12 October 2021

RE: RESPONSE TO REQUEST FOR ADDITIONAL INFORMATION FOR SSD-10224, NEW PRIMARY SCHOOL AT EDMONDSON PARK

2 NORTH - WEST ELEVATION (FAULKNER WAY)
0005 1 : 250

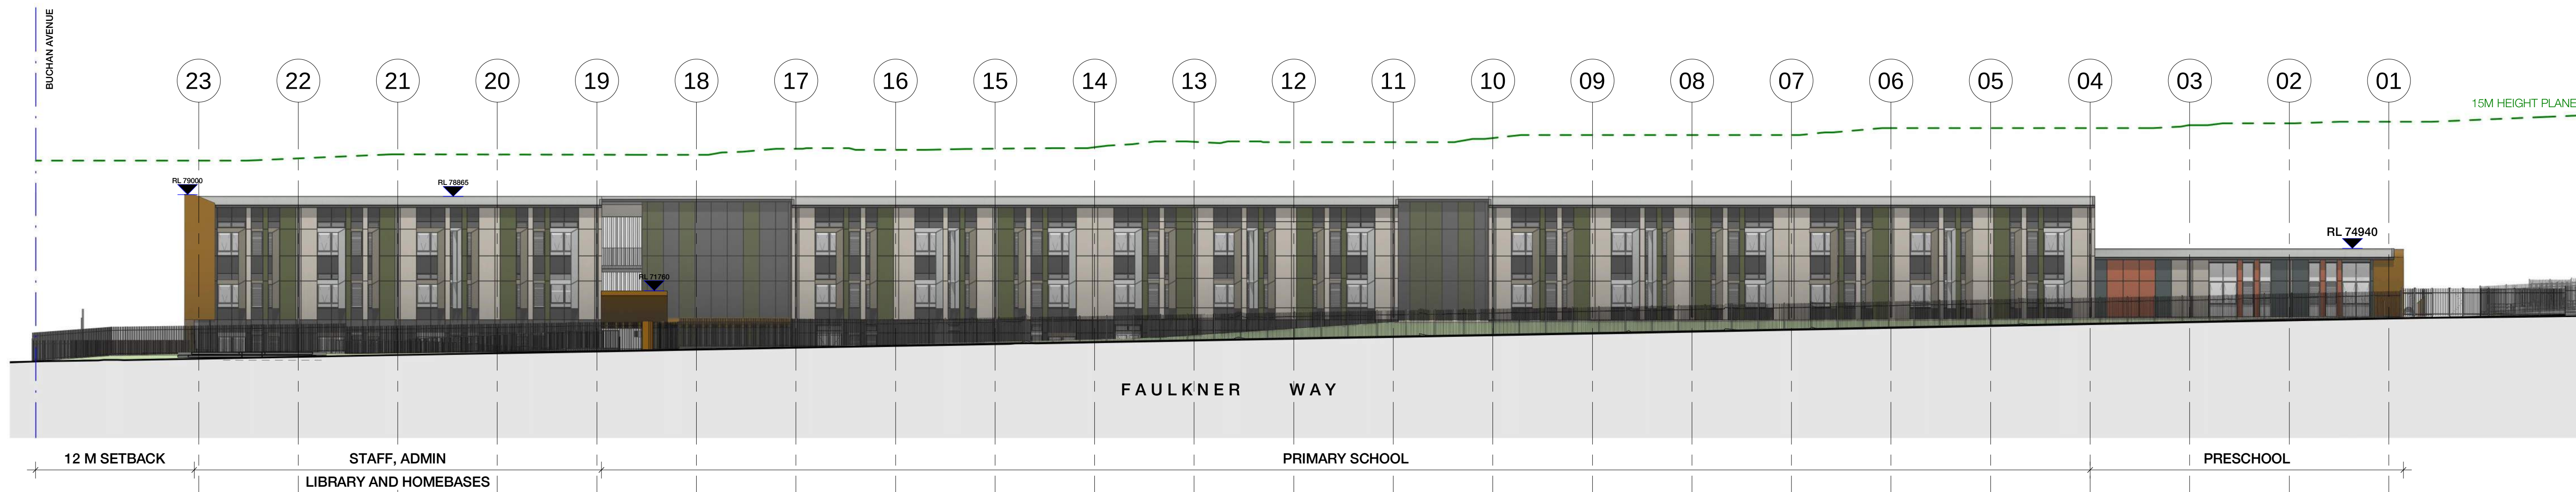
As shown on the Amended Architectural Plans in Appendix 2, SINSW seeks consent to amend the design of the sun-shades on the western elevation of the Faulkner Way building. The changes involve:

- Ground floor shading devices with horizontal blades only;
- Intermediate vertical blades removed from 2,140mm wide windows;
- Vertical blade elements removed from every second 800mm wide window, providing horizontal shading device only; and
- Blade depths consolidated to two proprietary dimensions – 427mm and 727mm.

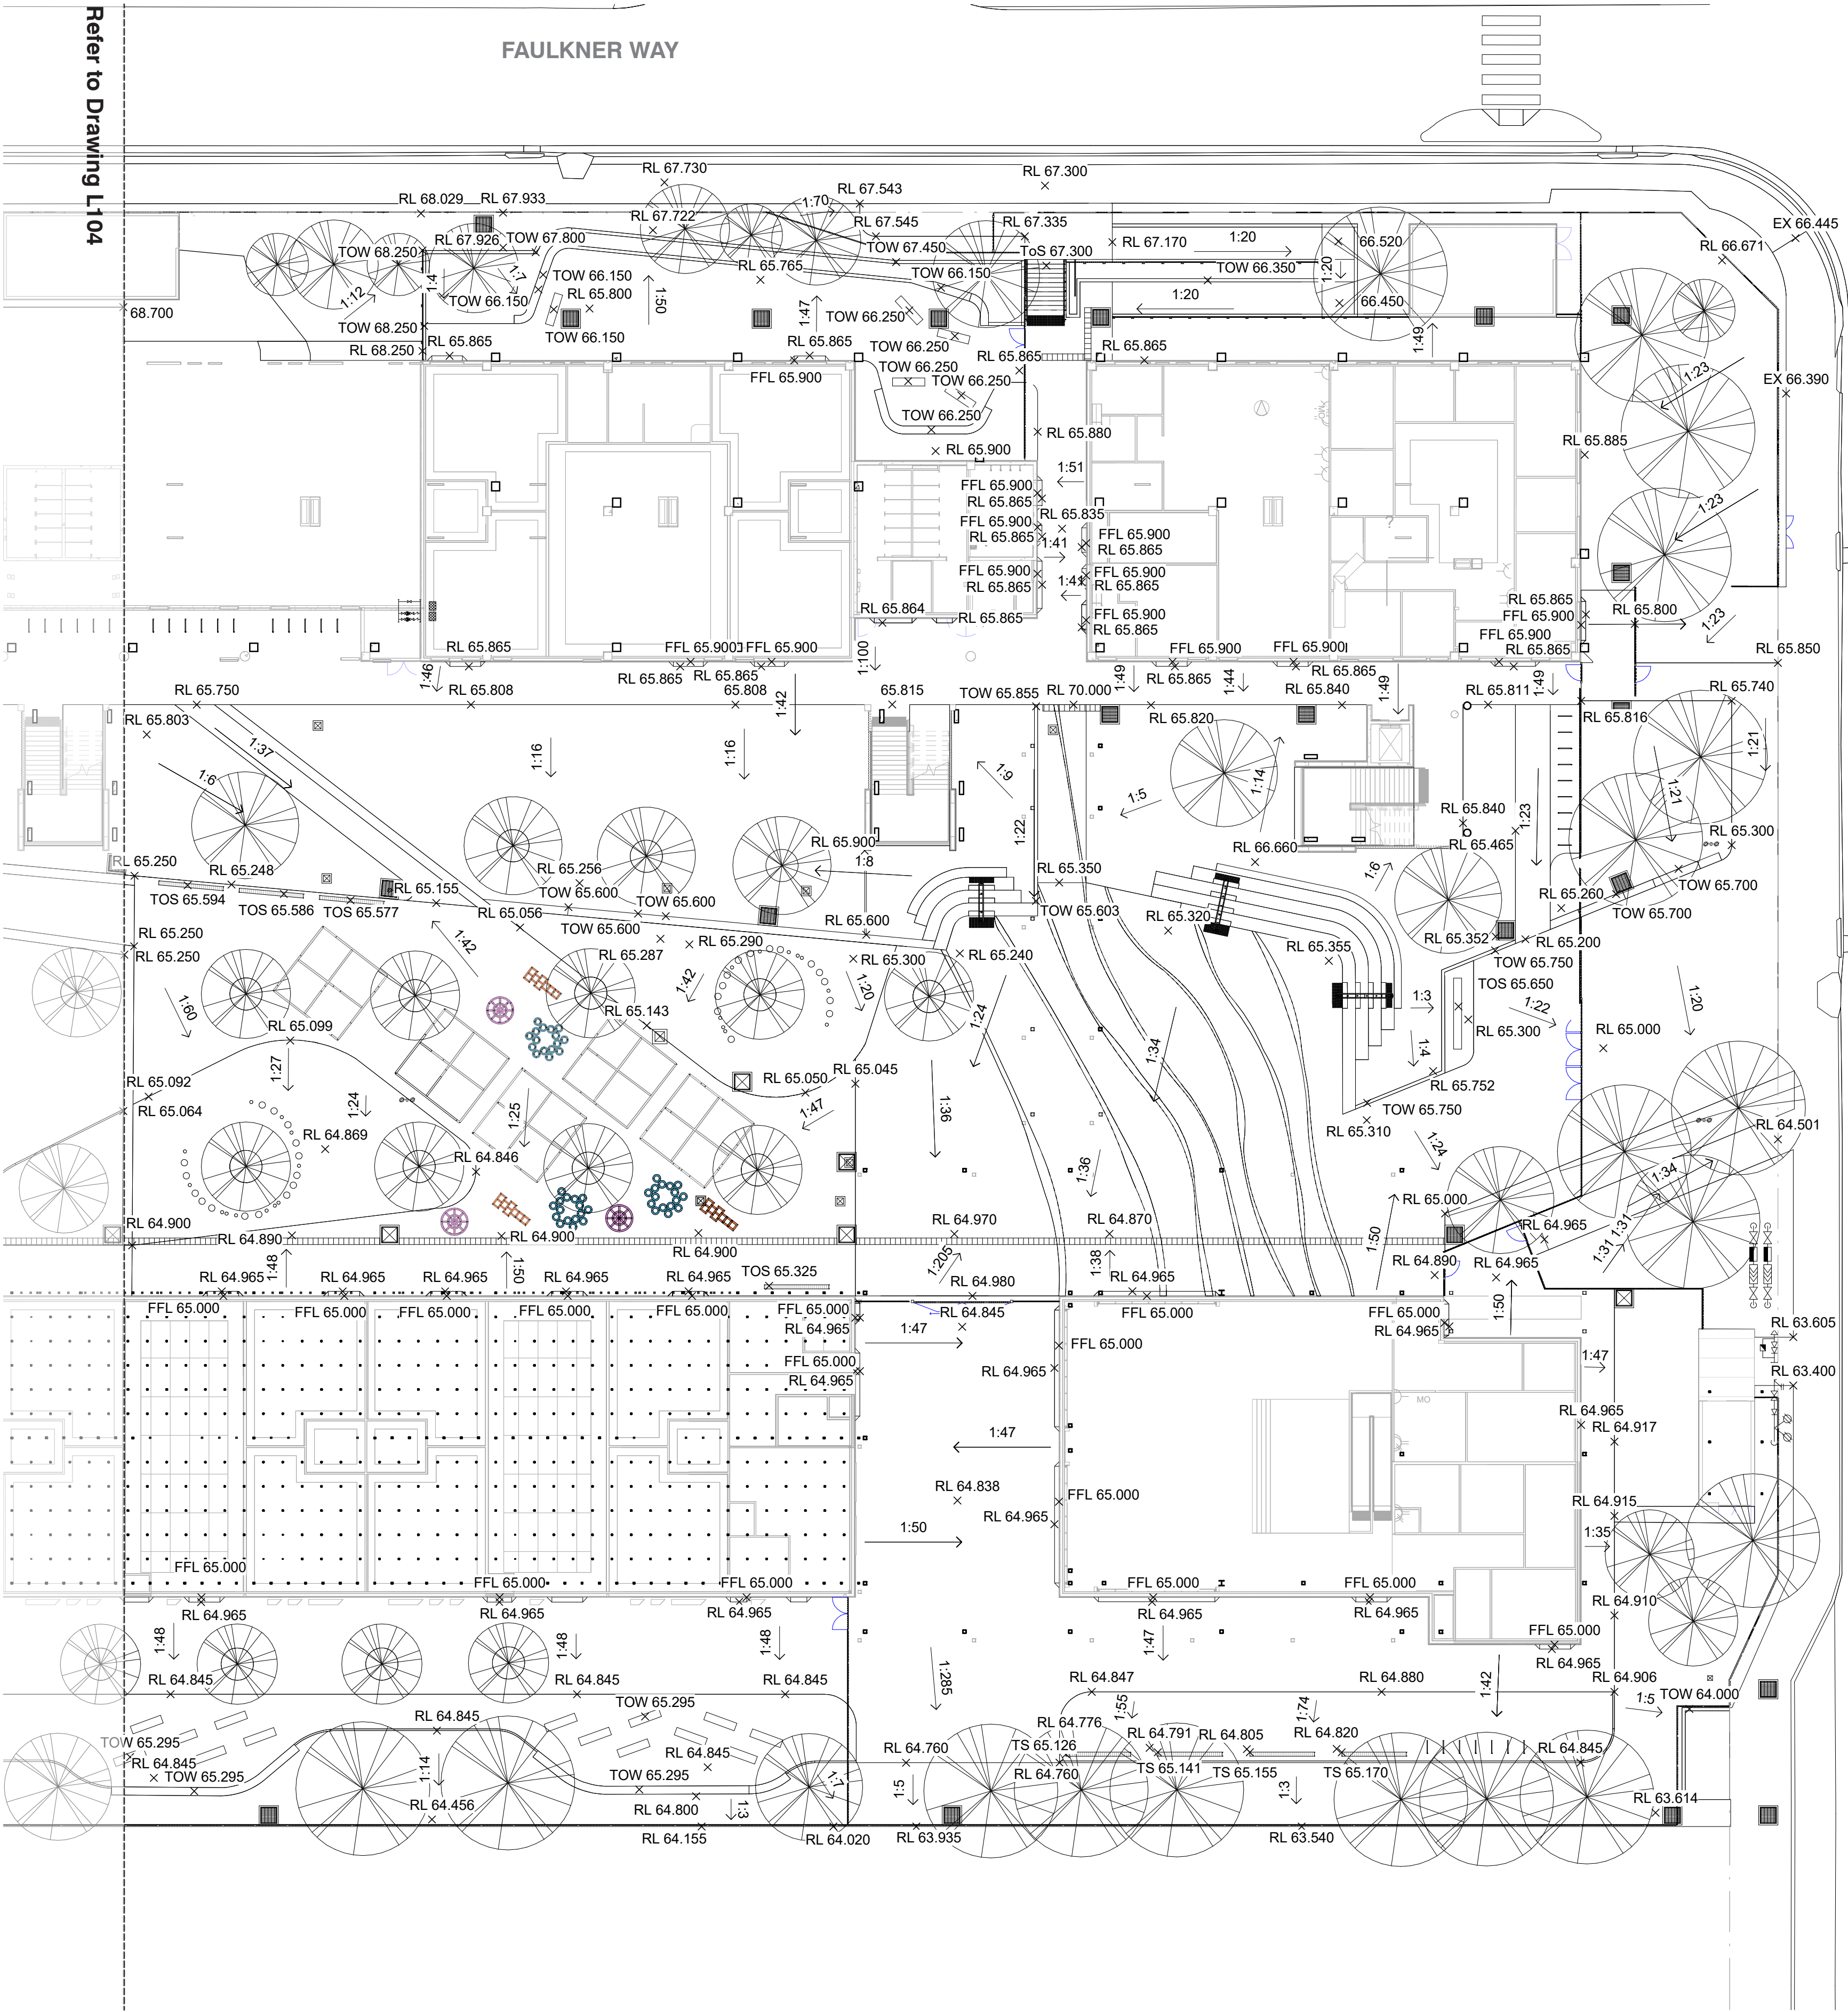
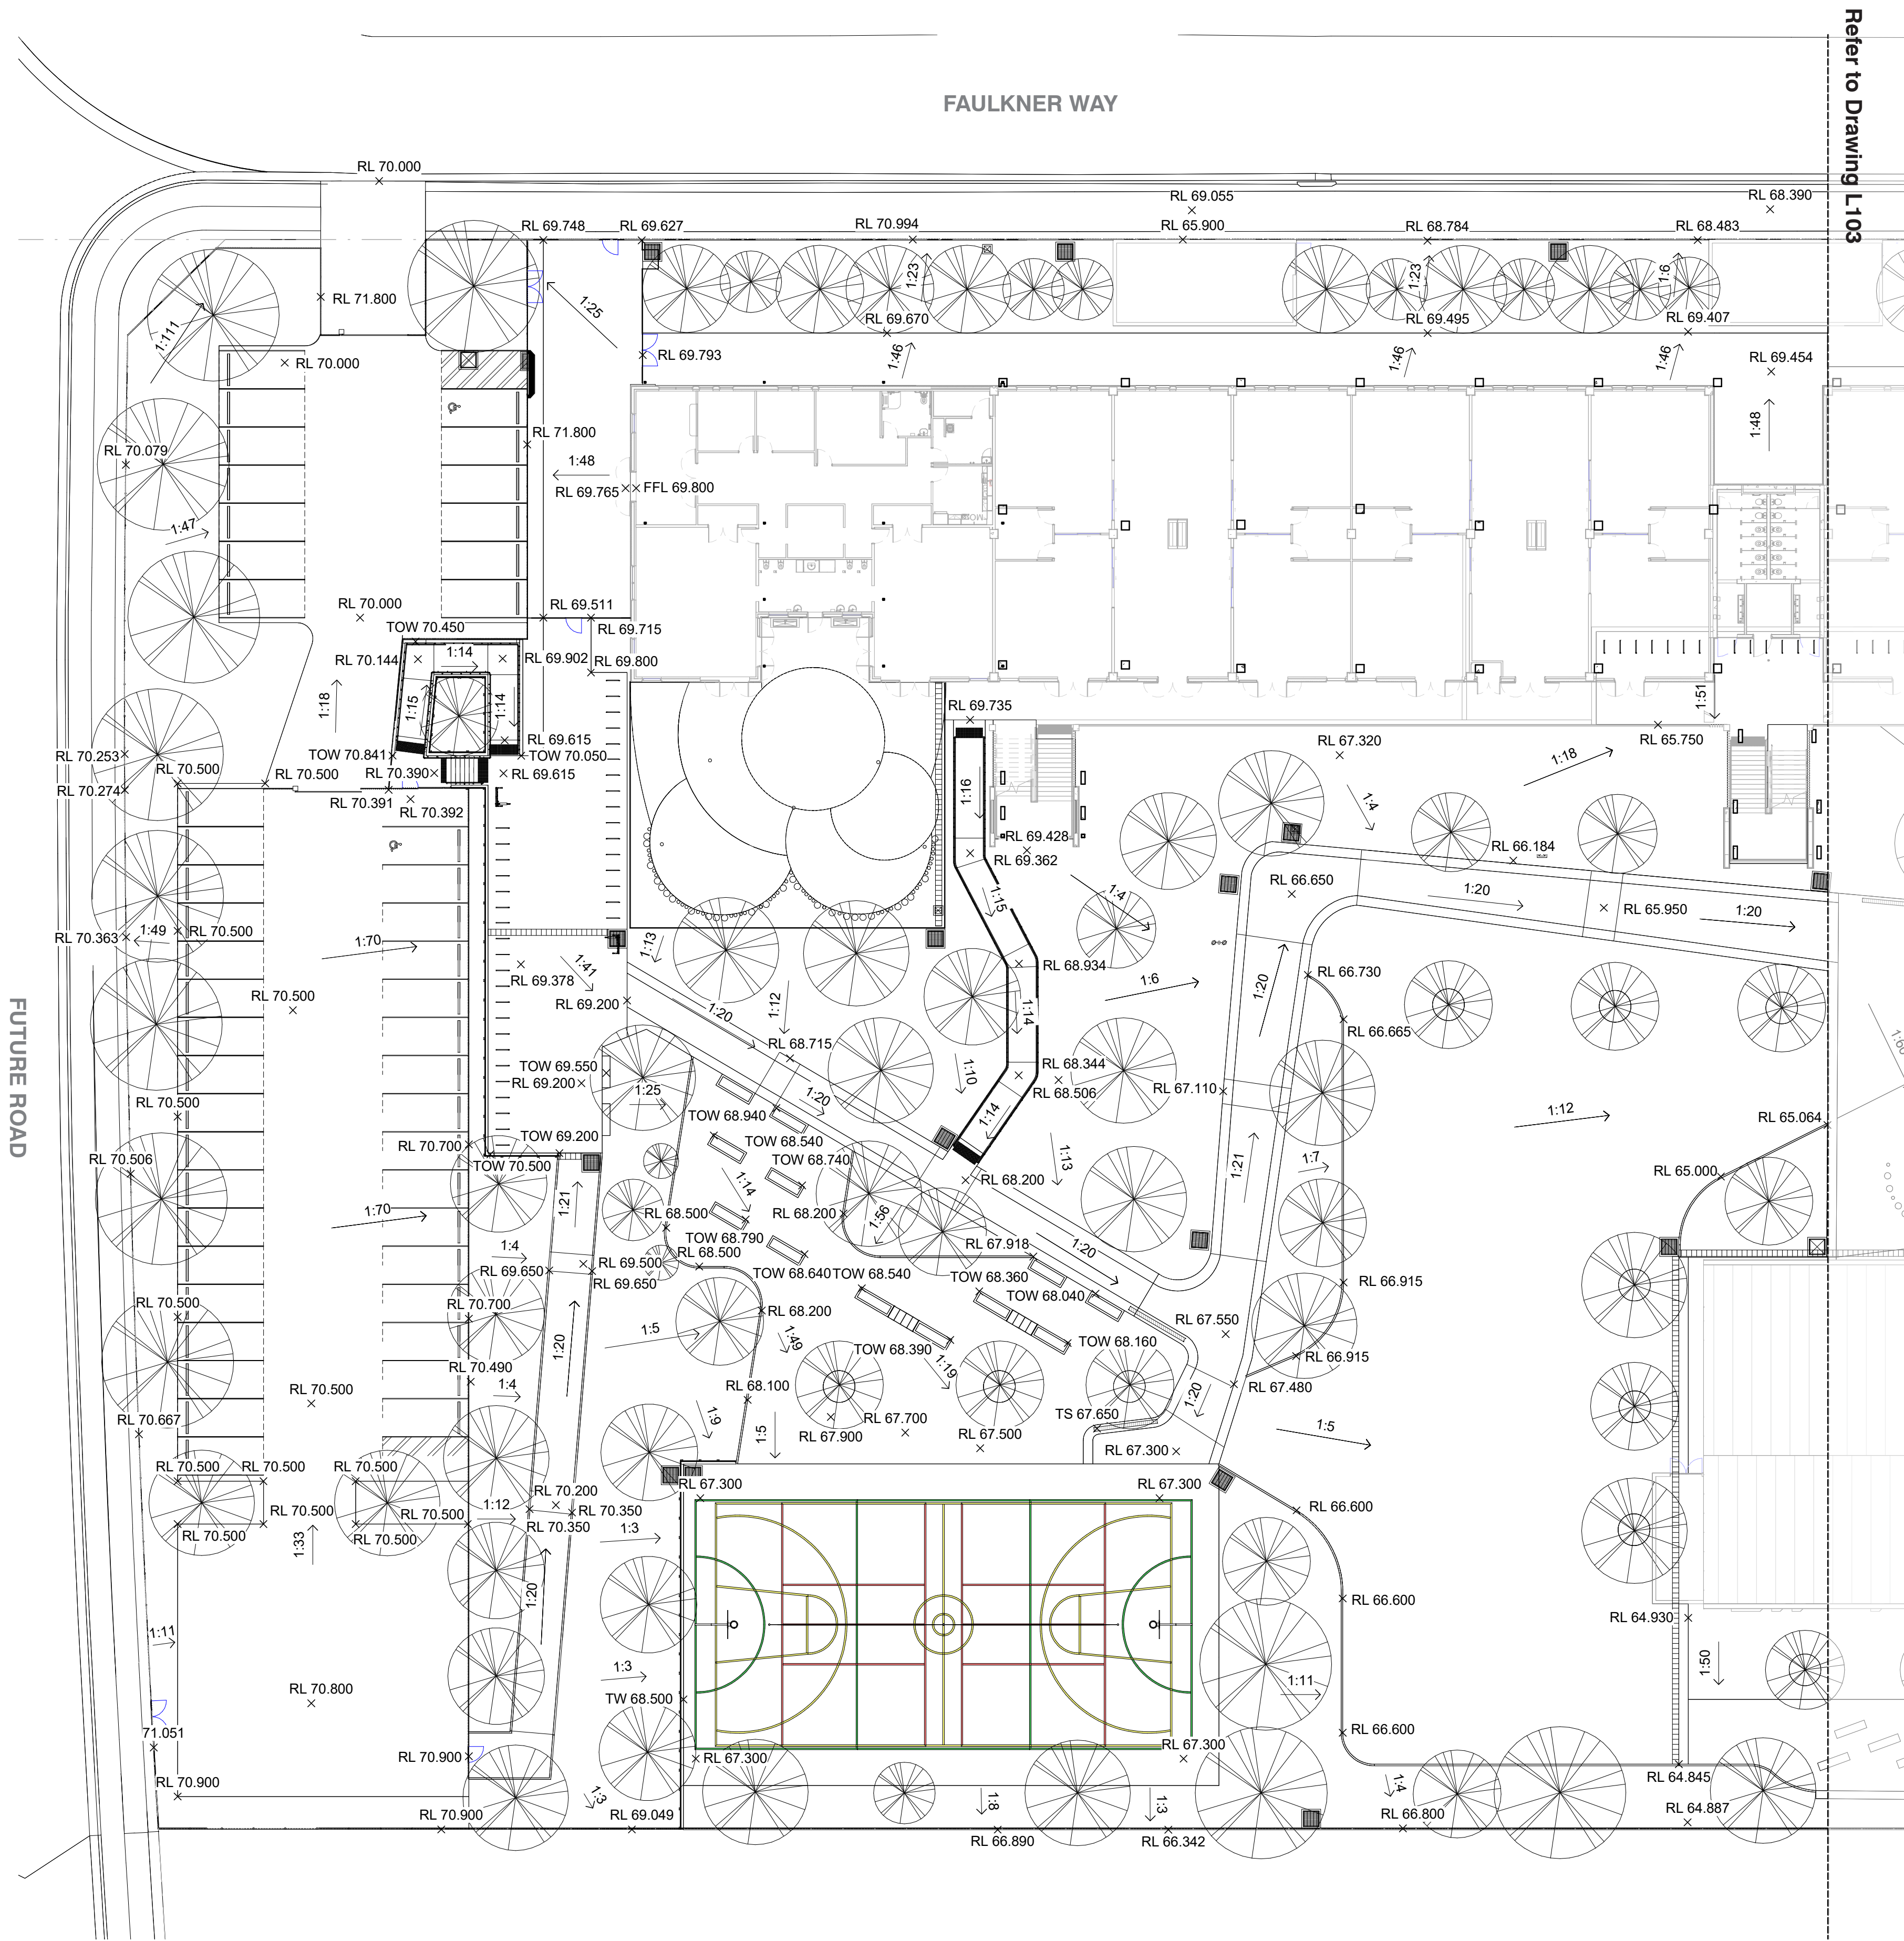
4 – Tree Removal and Landscaping	In response to Council's submission, Oculus has clearly identified multi-line markings on the Games Court. In addition, other minor landscape changes

- Inclusive access provided to the sports court
- Sports court line markings added as per Education Facilities Standards and Guidelines requirements
